**KIRKLEES METROPOLITAN COUNCIL
INVESTMENT & REGENERATION SERVICE**

**DELEGATED DECISION TO DETERMINE APPLICATIONS FOR
NON-MATERIAL AMENDMENTS**

Reference No: **2023/NM/90352/W**

Description: Non material amendment to previous permission
2021/94601 for erection of educational building and
associated works

Title  
PROPOSED SITE VIEWS

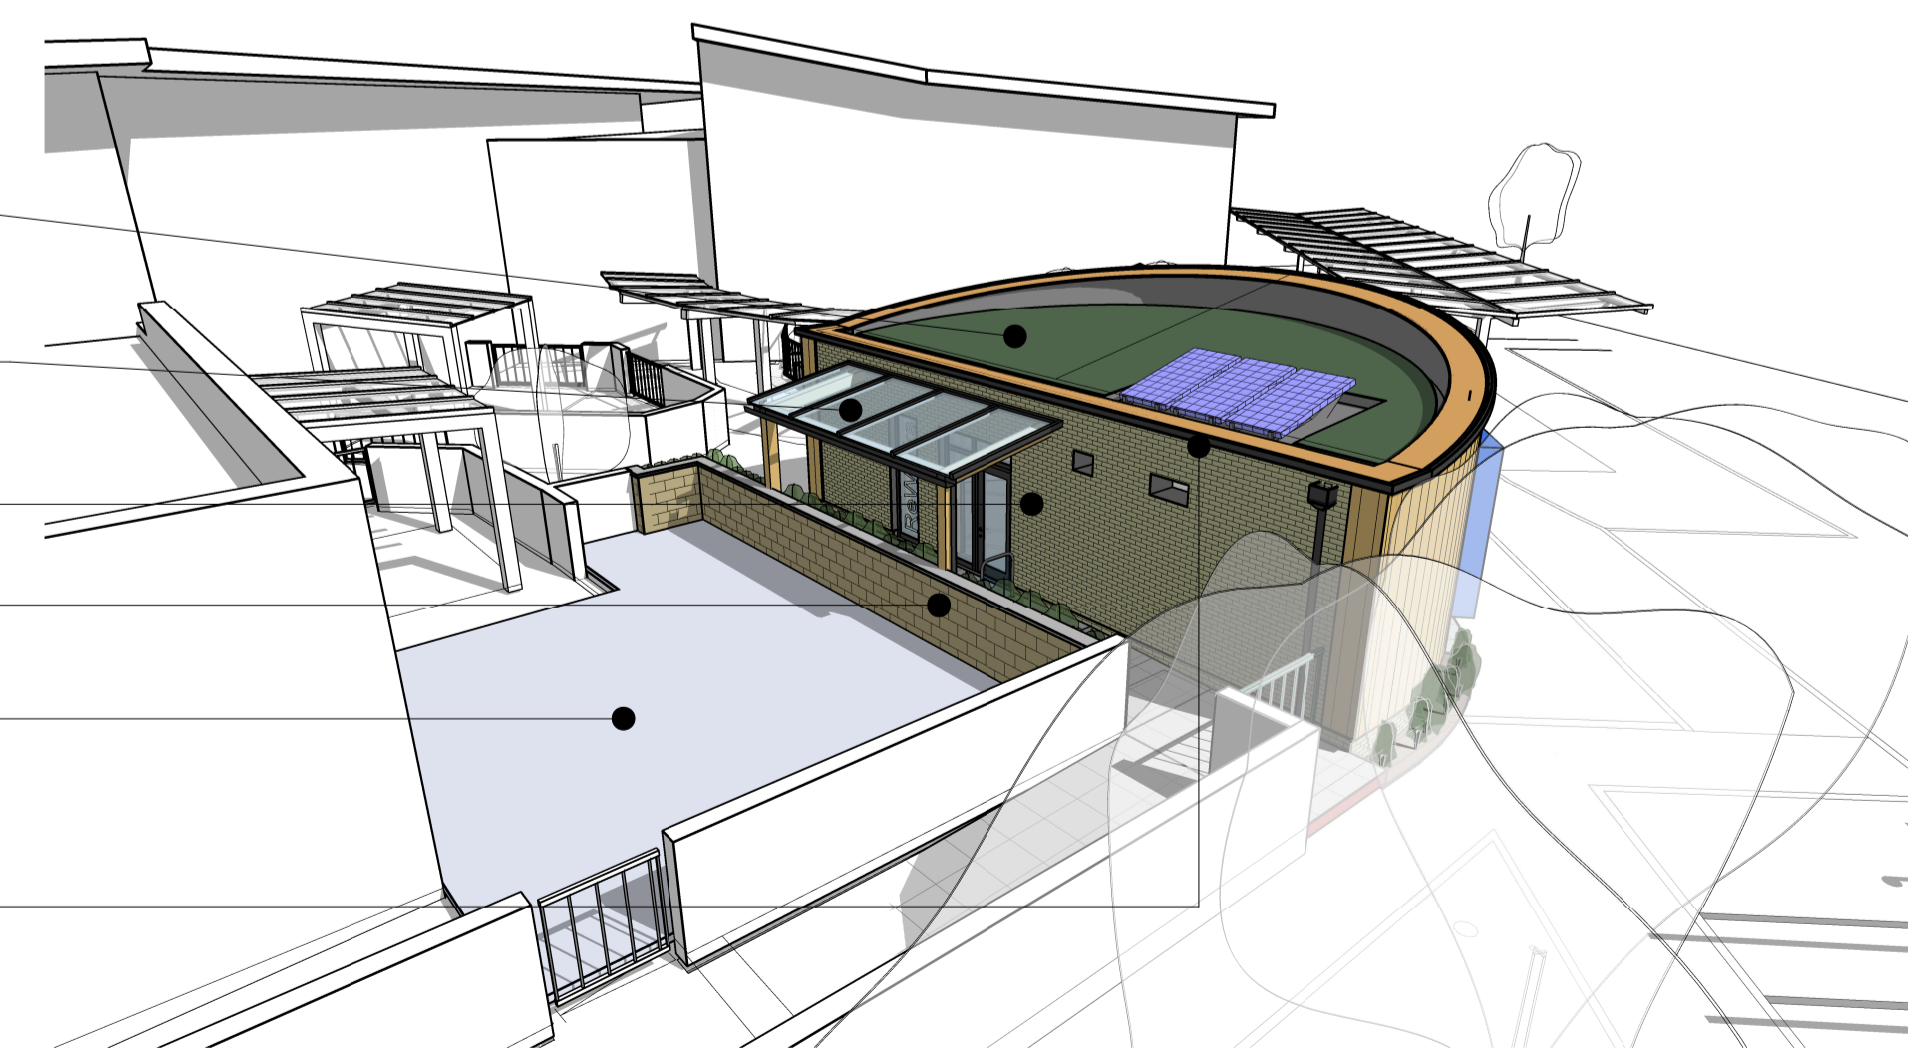
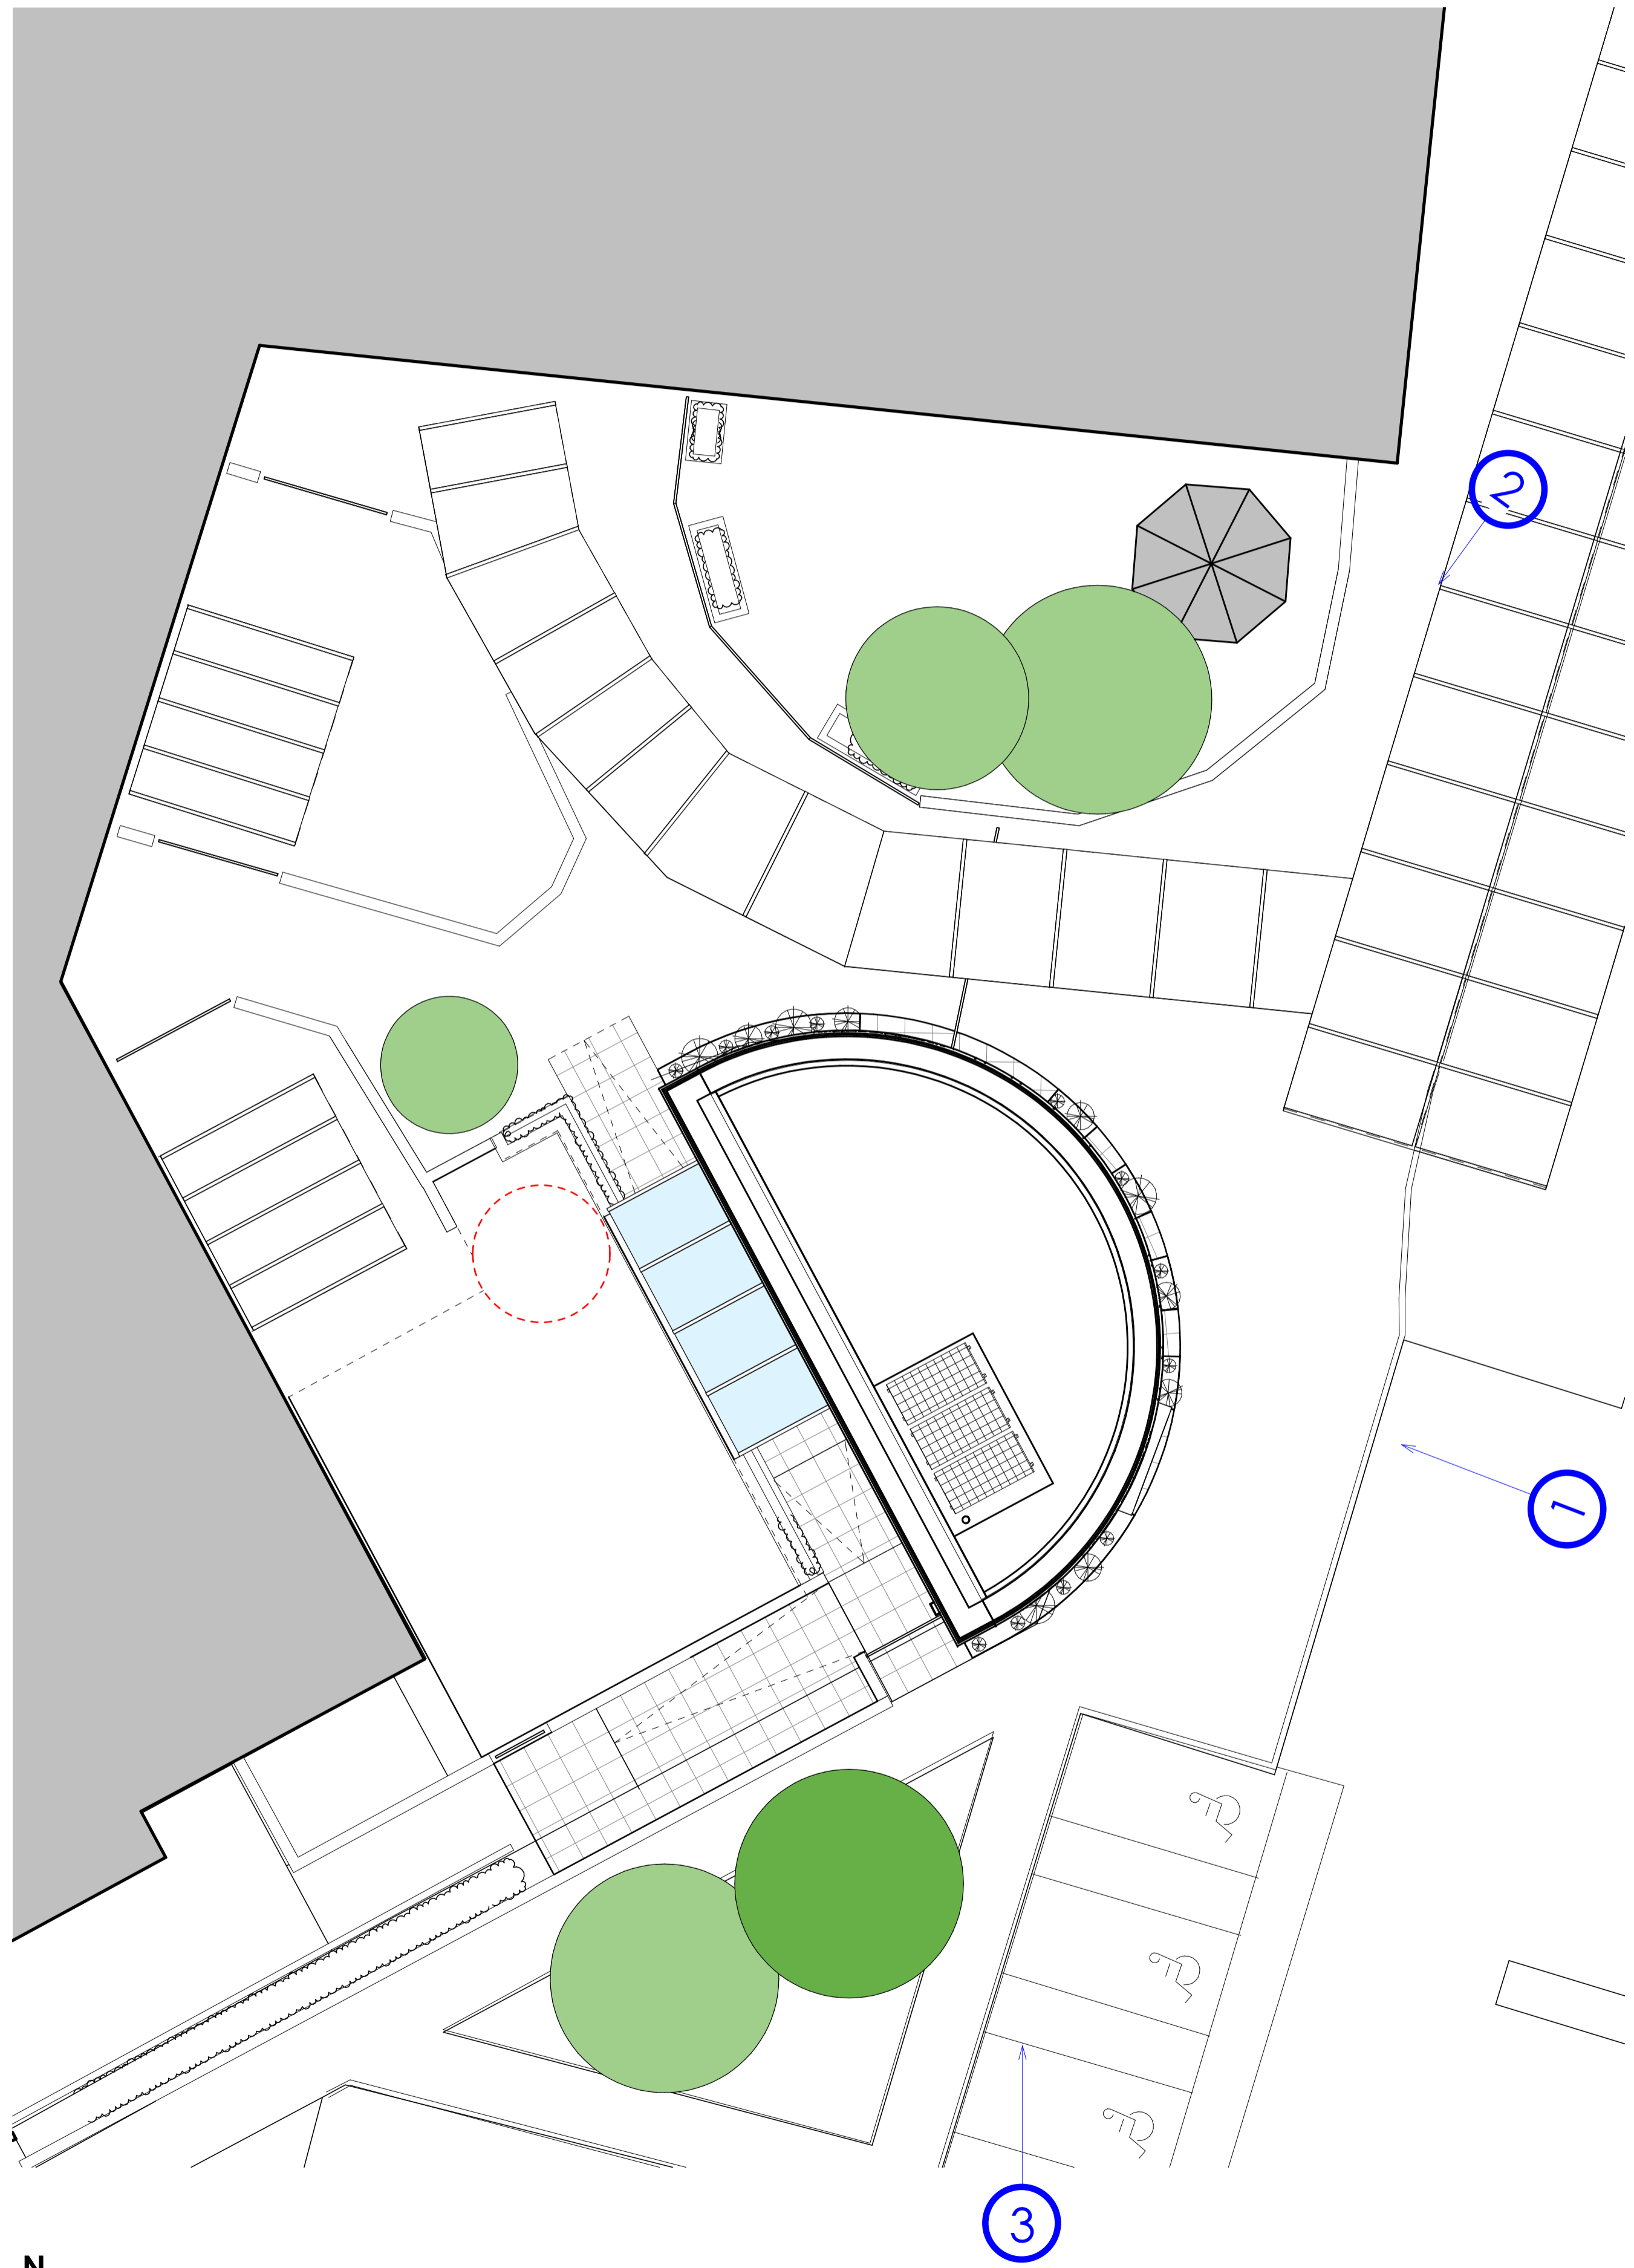
- The removal of the recess to the rear of the building
- A slight change to the colours of the external frames
- Erection of external wall to replace planting between access route and play area for child safety
- Relocation of the solar panels within the roof
- Removal of a small shrub in play space for safety purposes
- The play space re-laid in rubber to match existing
- The access route around existing play areas re-laid

The amendments sought are to remove the recess to the rear of the building, slightly change the colour to the external frames, re-locate the solar panels within the roof, erect an external wall to replace the planting between the access route and play area for child safety, remove a small shrub in the play space for safety purposes, re-lay the play area in rubber and access route in matching materials, as shown on drawings 12335 -WMS - XX -XX - DR - A - 10400 -D2 - P3 (proposed site plan), and 12335 -WMS -XX - XX - DR - A - 10410 -D2 -P4 (proposed roof plan) 12335 -WMS - XX -XX - DR - A - 10401 - D2 - P6 (proposed site views).
